EL PASO COUNTY GRADING AND EROSION CONTROL PLAN CHECKLIST

EPC Project Number: CDR-22-013

**Figure
Number
4 WEST**

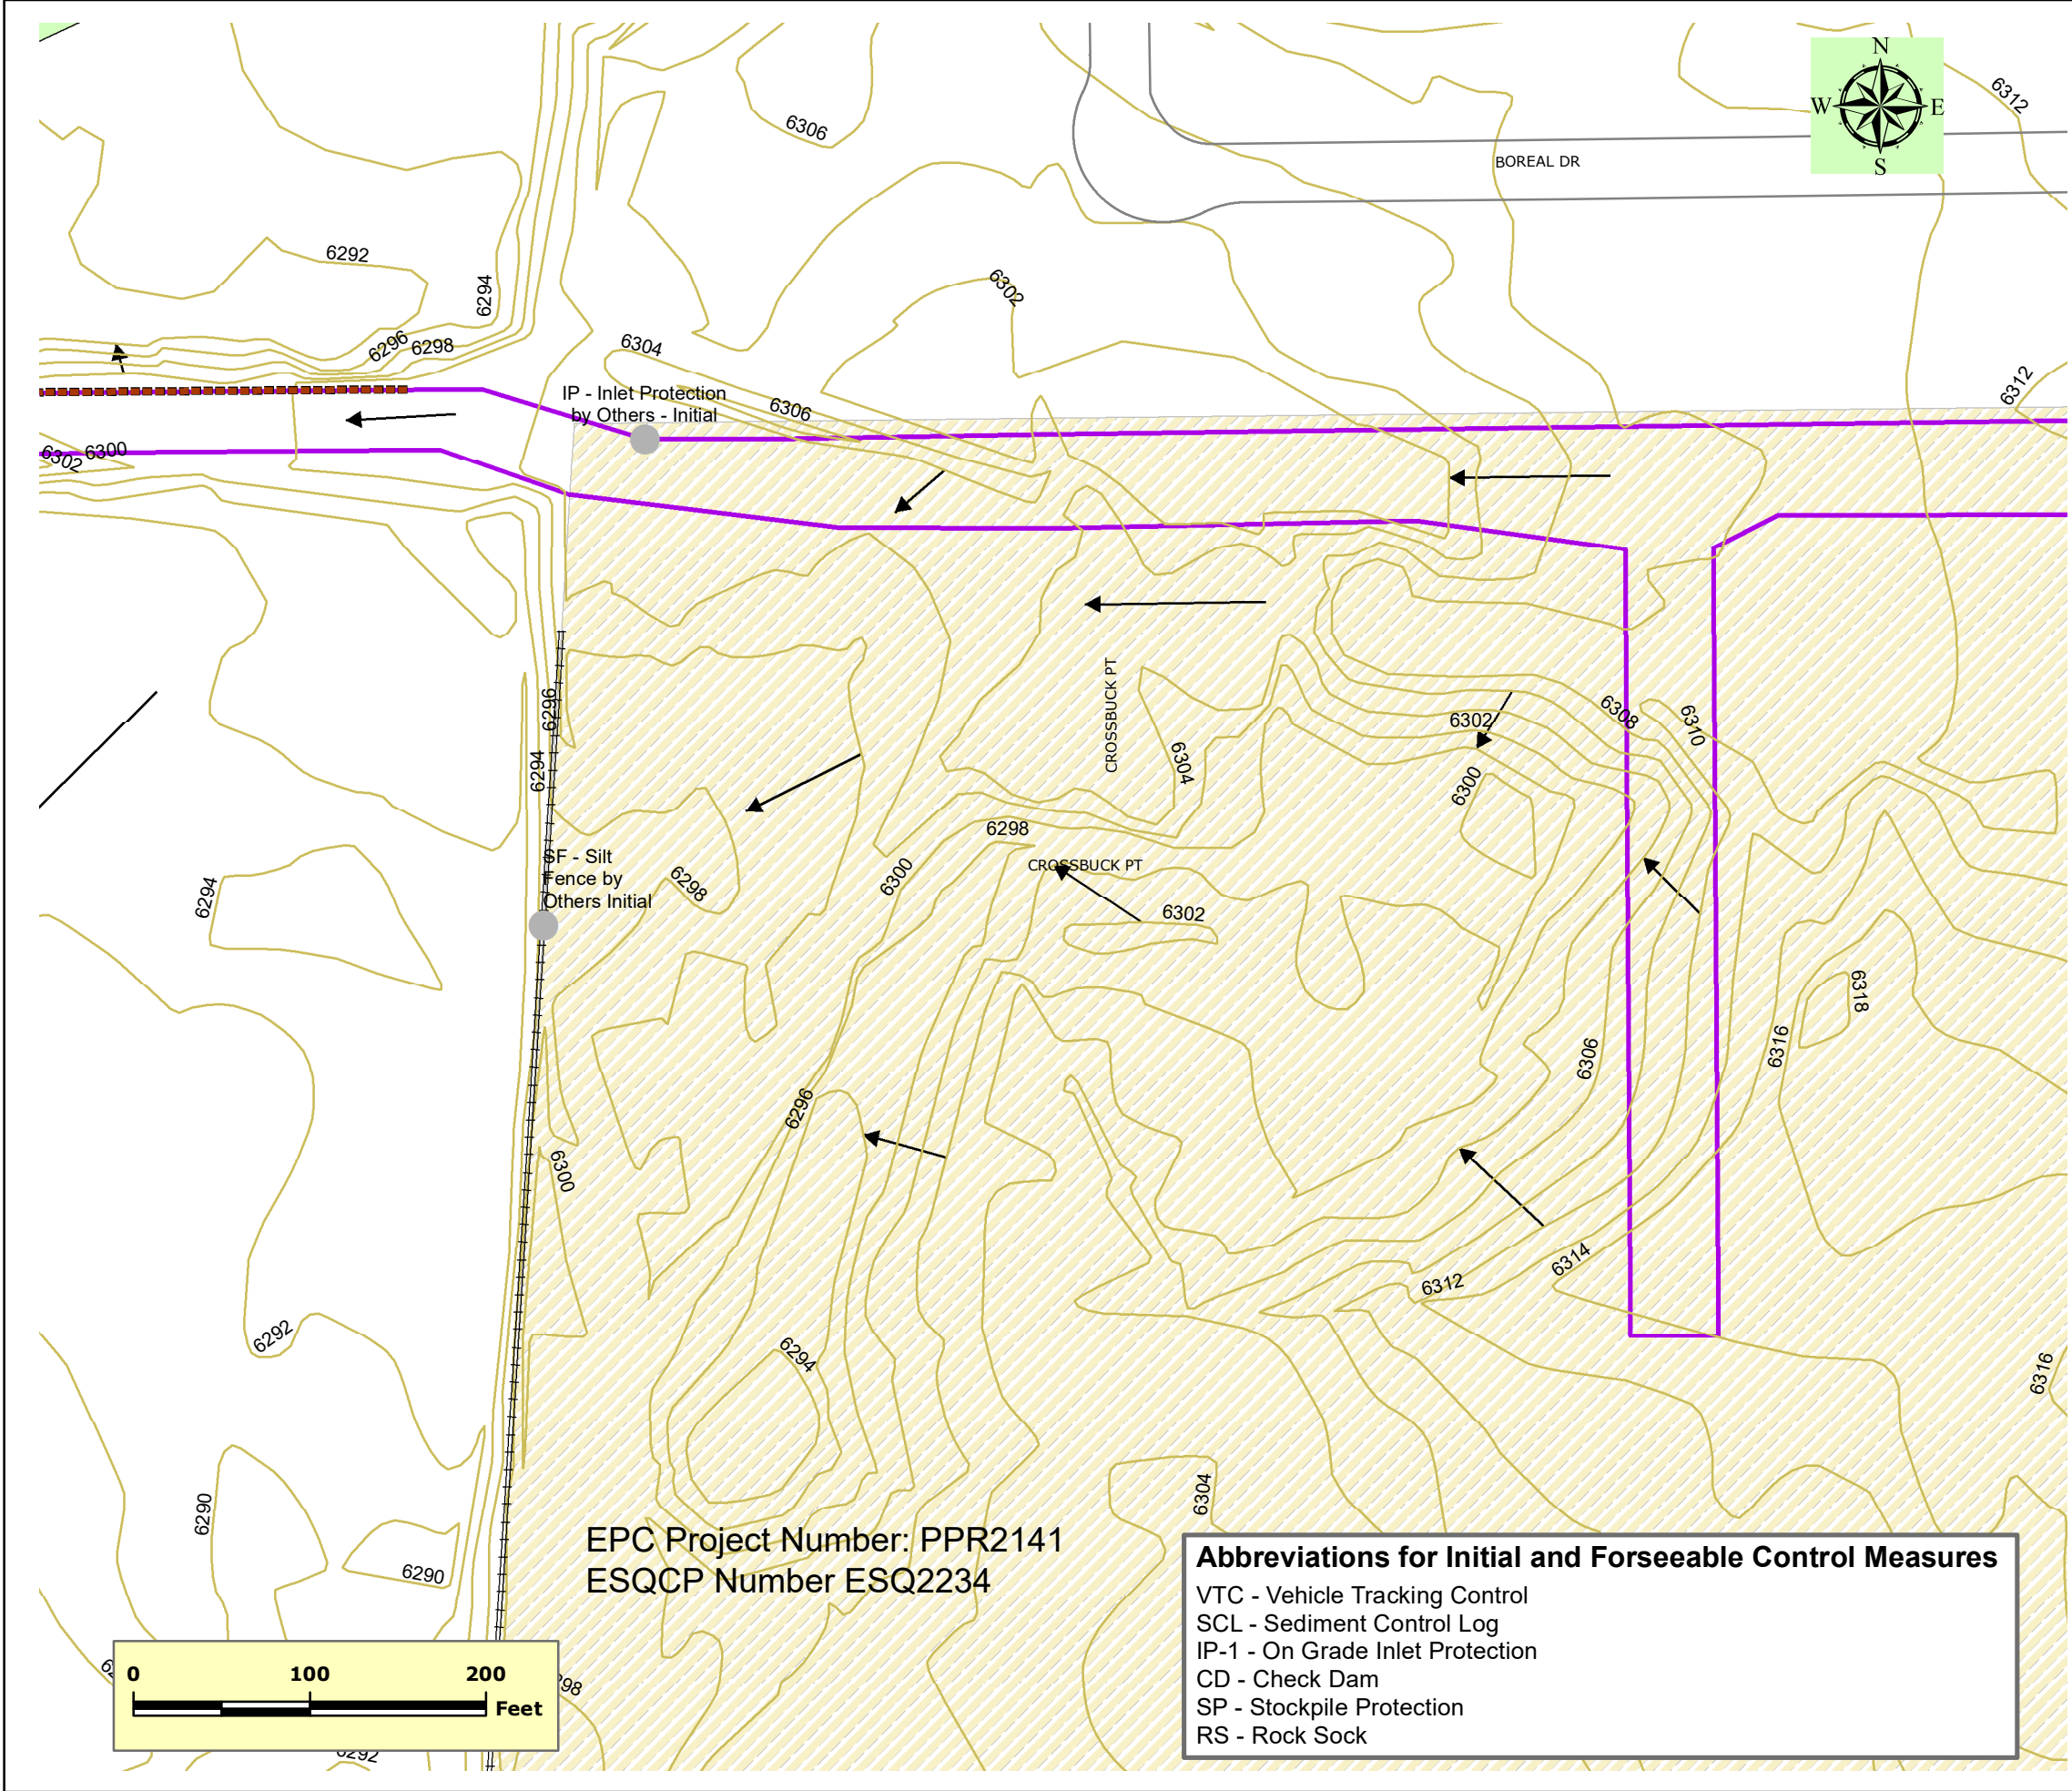
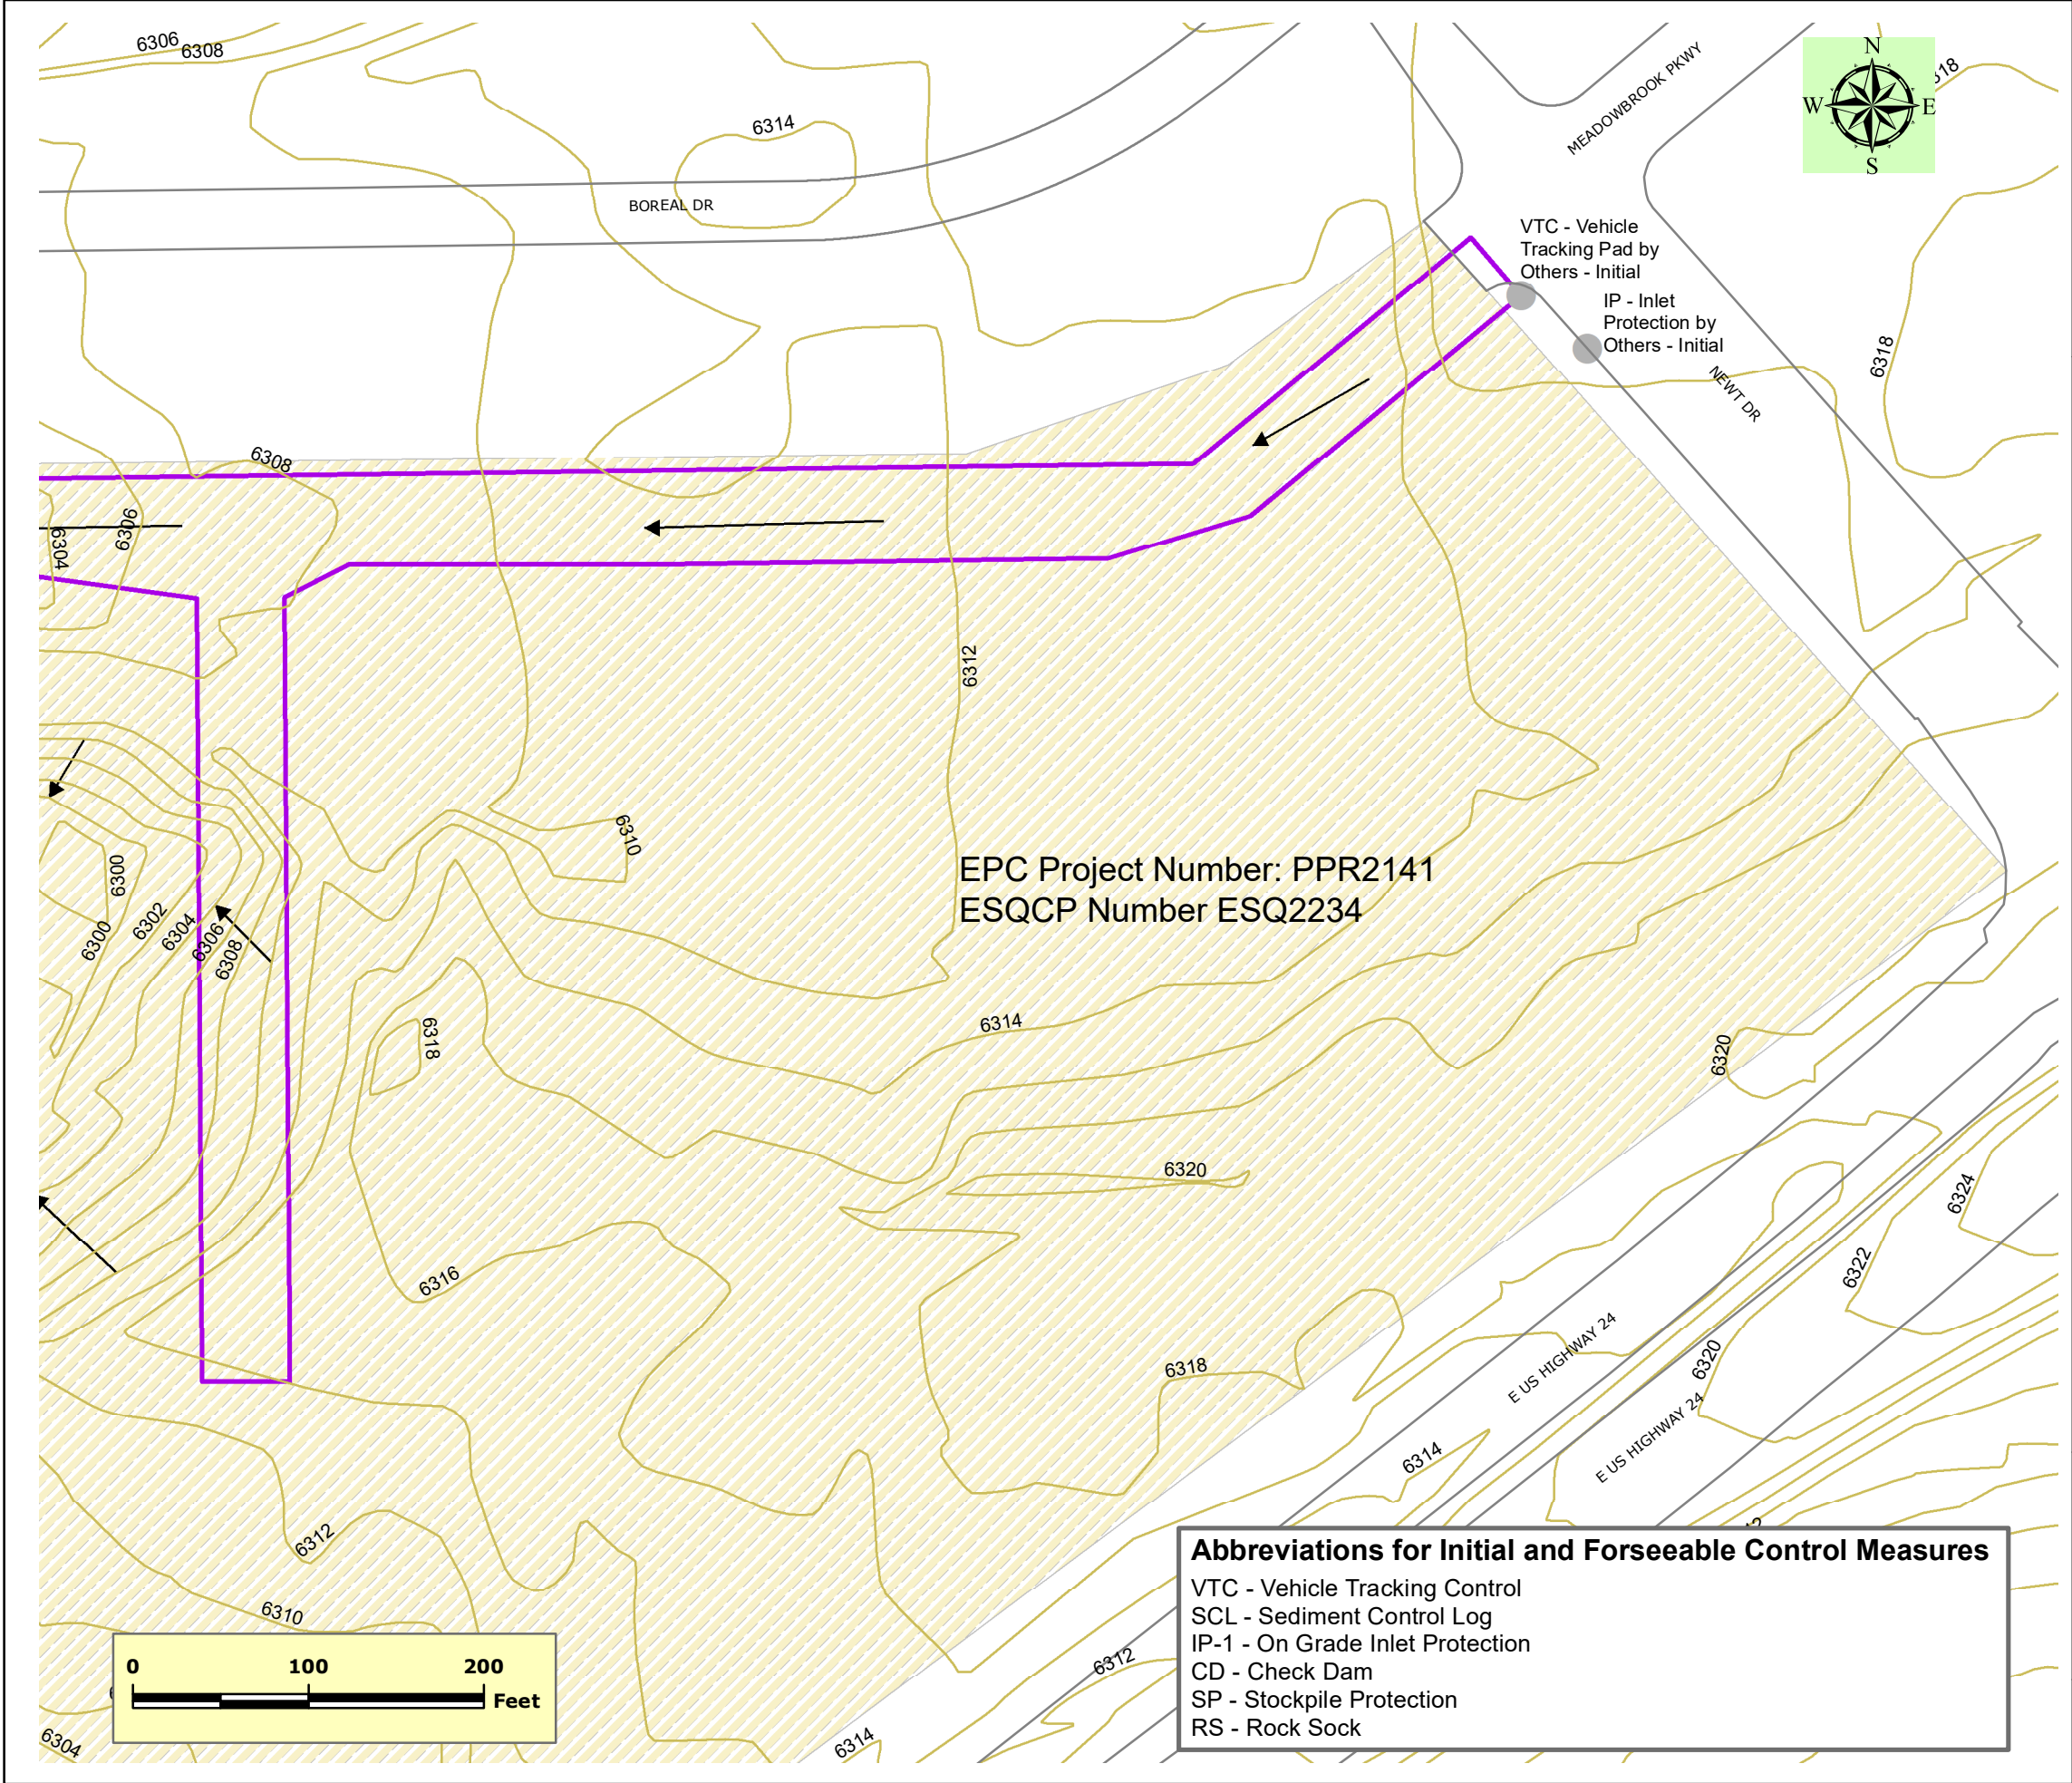
l	Existing and proposed contours 2 feet or less (except for hillside)		✓
m	Limits of disturbance delineating all anticipated areas of soil disturbance		✗
n	Identify and protect areas outside of the construction site boundary with existing fencing, construction fencing or other methods as appropriate	Fig 4 Note 5	✗
o	Off-site grading clearly shown and called out		N/A
p	Areas of cut and fill identified All disturbed areas to be returned to pre-construction elevations.		N/A
q	Conclusions from soils/geotechnical report and geologic hazards report incorporated in grading design (slopes, embankments, materials, mitigation, etc.)		✓
r	Proposed slopes steeper than 3:1 with top and toe of slope delineated. Erosion control blanketing or other protective covering required		N/A
s	Stormwater flow direction arrows		✗
t	Location of any dedicated asphalt / concrete batch plants		N/A
u	Areas used for staging, storage of building materials, soils (stockpiles) or wastes. The use of construction office trailers requires PCD permitting		✓
